From  
THE MEMBER-SECRETARY,  
Chennai Metropolitan  
Development Authority,  
No.8, Gandhi Irwin Road,  
Chennai: 600 008.

Letter No. B1/16710/98.

Sub: CMDA - APU - PP - Proposed Construction of  
GF+3F Residential Flats with 68 D.U for L.G.G.S constructed  
by TNHB ~~at second cross street~~, at second cross street, major Trust puram,  
Chennai 84.

SECTION-AB

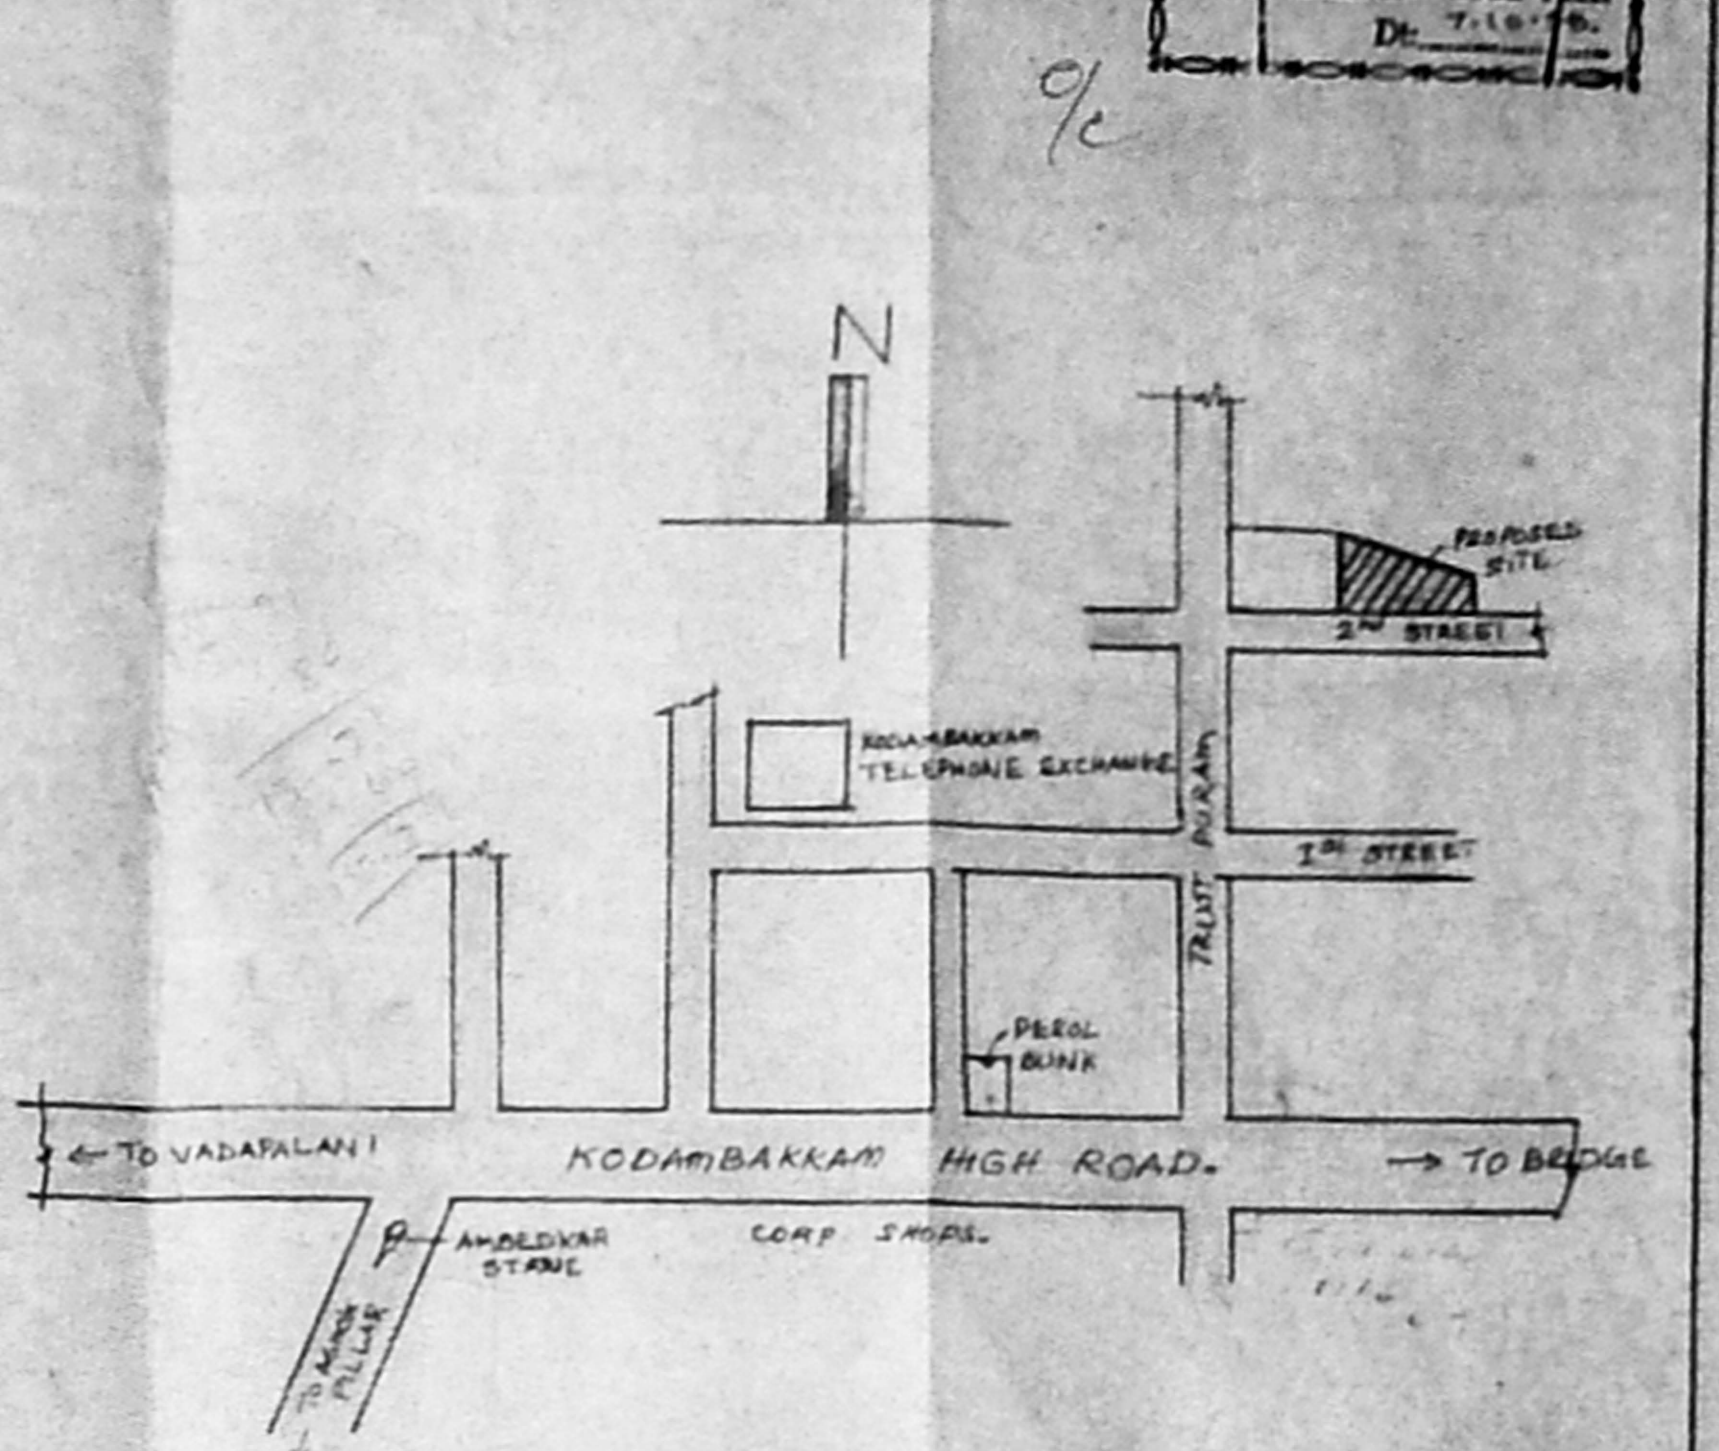
6) I am to request you to furnish Revised plans showing:-

a) Total height of the structure

b) Basement height to be shown as 0.91 met as per the requirements of C.M.W.S.S.B.
